An
Bord
Pleanála

Memorandum
ABP-316212 – Request for
further information

To: Stephen Kay, ADP
From: Bríd Maxwell, Planning Inspector
Re: 316212
Date: 7th May 2024

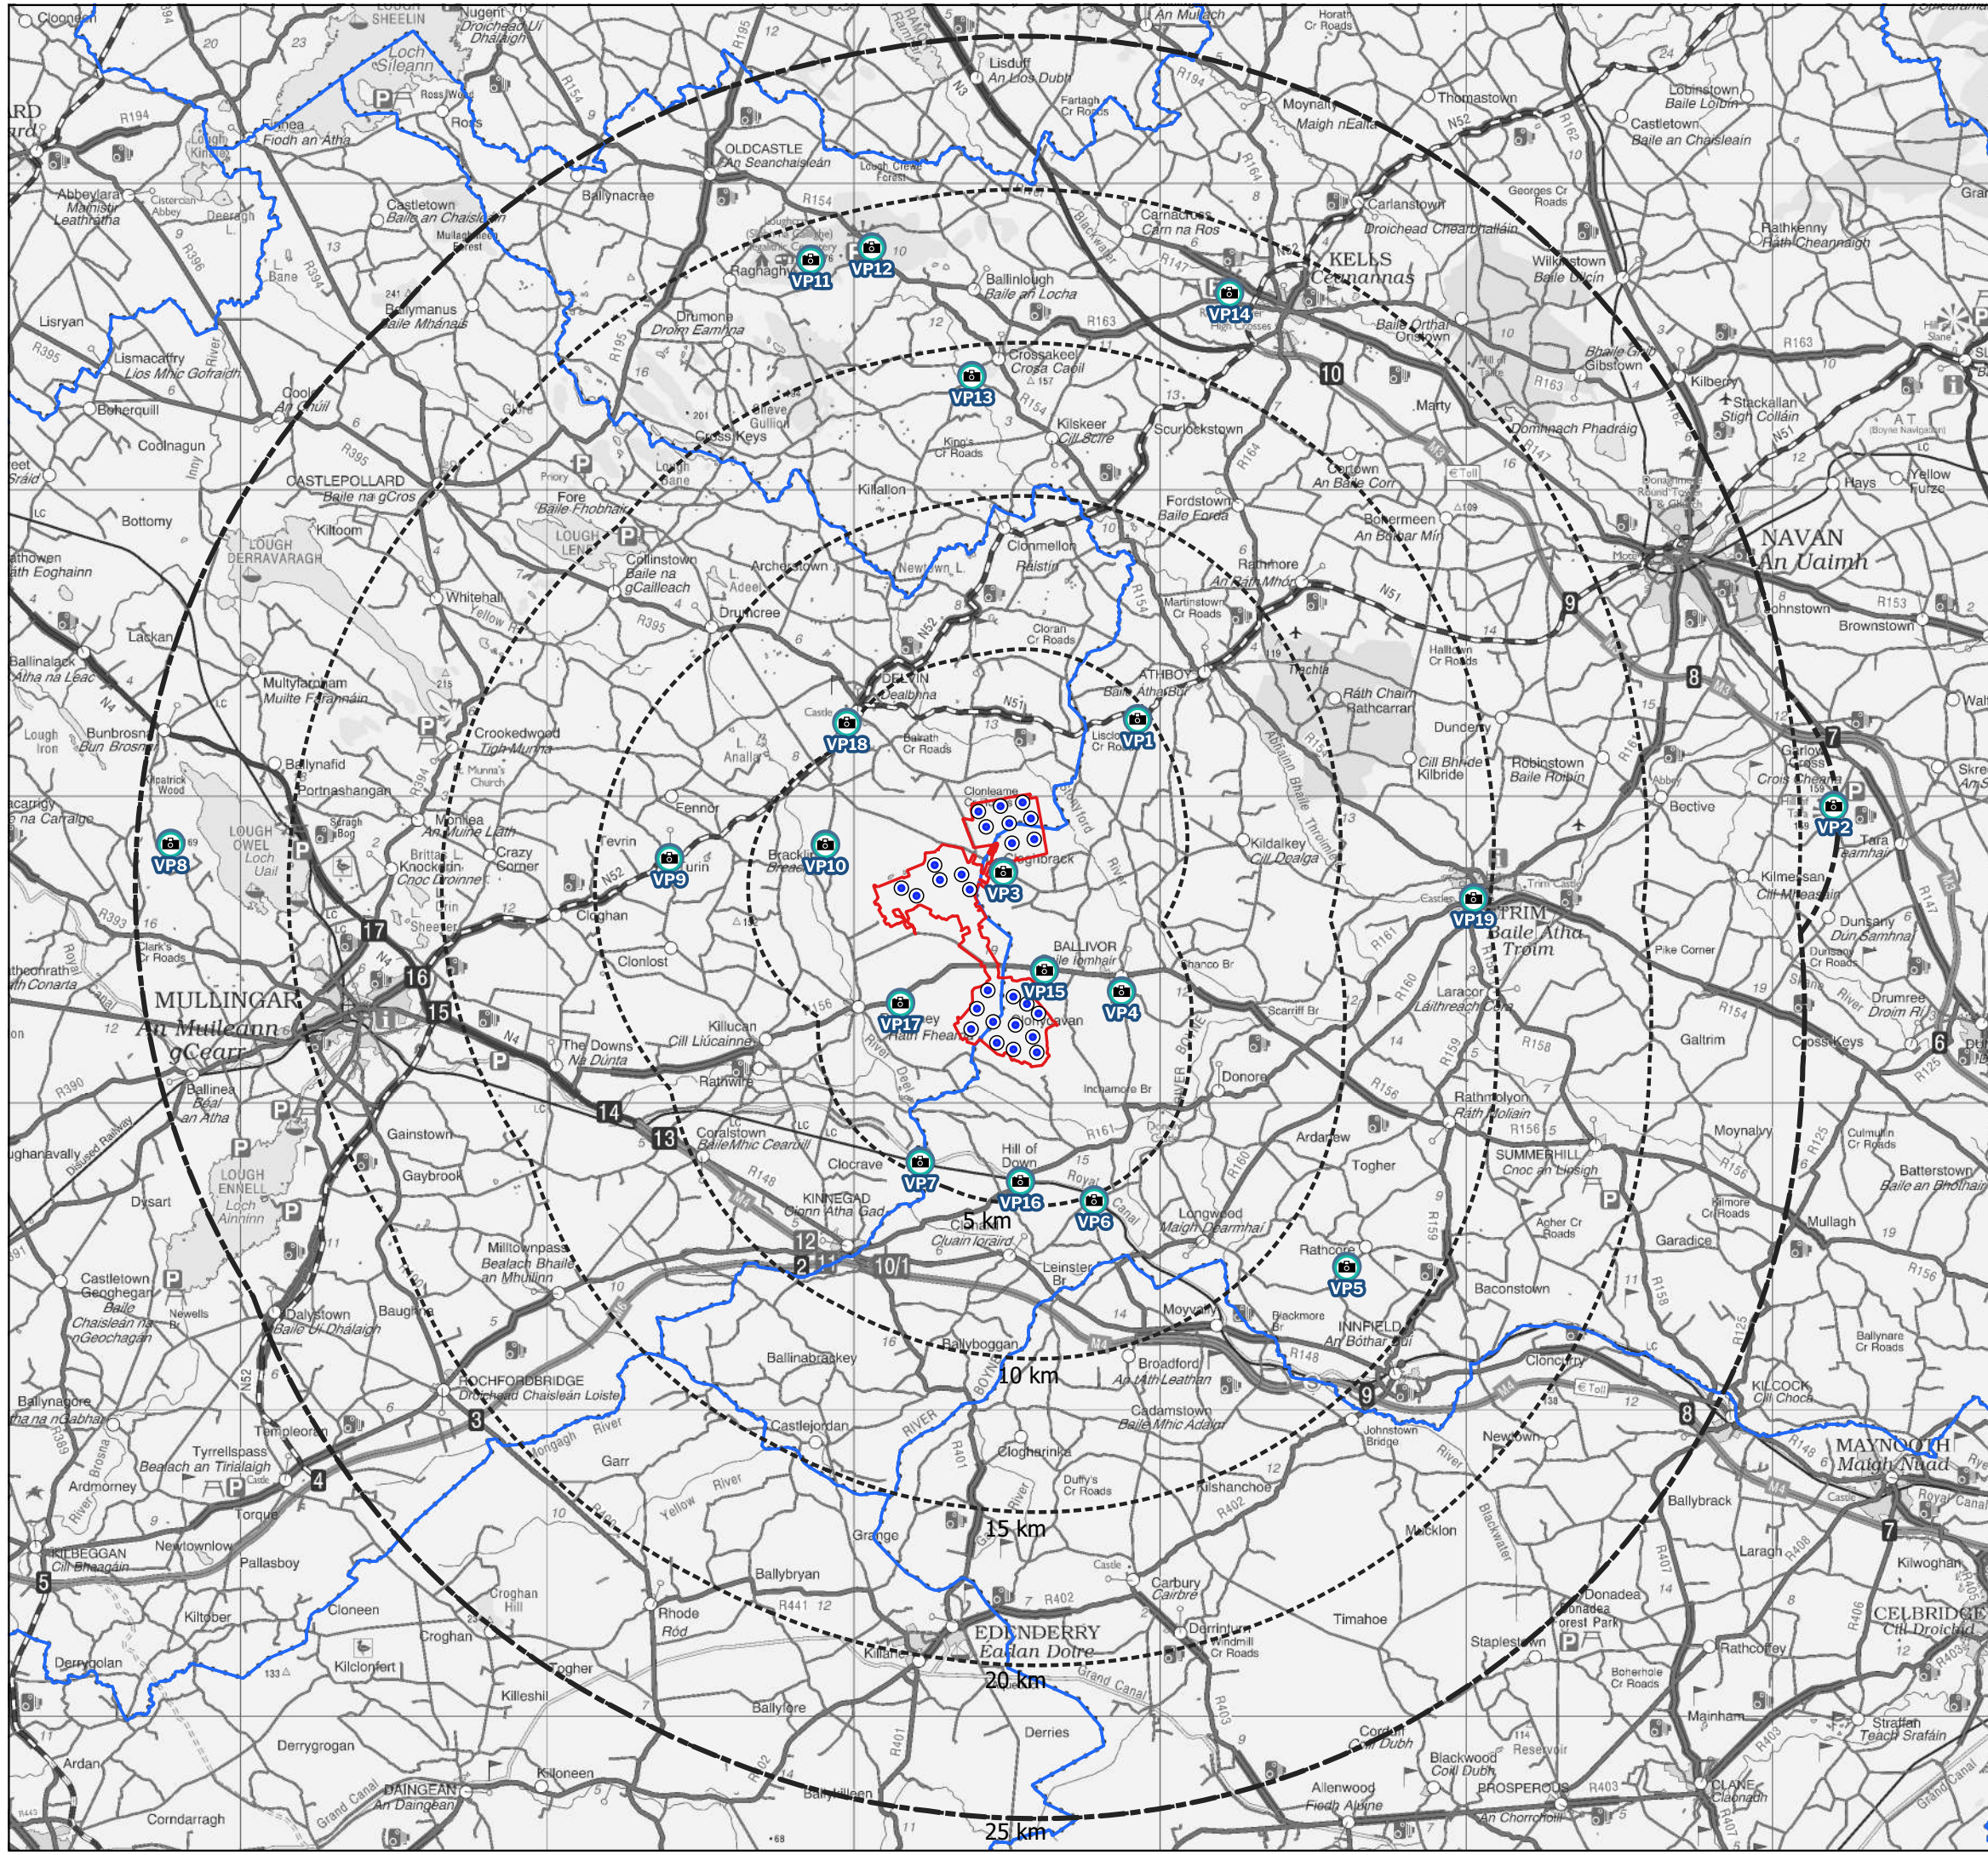
The applicant is advised to note that the ZTV mapping colour banding error evident on the initial half blade ZTV map Fig 13-1 (digital and hard copy), a digital malfunction as referenced by you in the response to the observations, is also evident within the digital copy of further information on the standalone website - [Response to Observations Received \(ballivorwindfarmplanning.ie\)](https://ballivorwindfarmplanning.ie) at Fig 5 and Fig 13.1, though the colour banding is present on the hard copy documents submitted to the Board. It is acknowledged that the colour banding is evident (digital and hard copy) on several of the other mapping figures included within the EIAR including the LVIA baseline map Fig 13-5, and landscape character areas Fig 13-11.
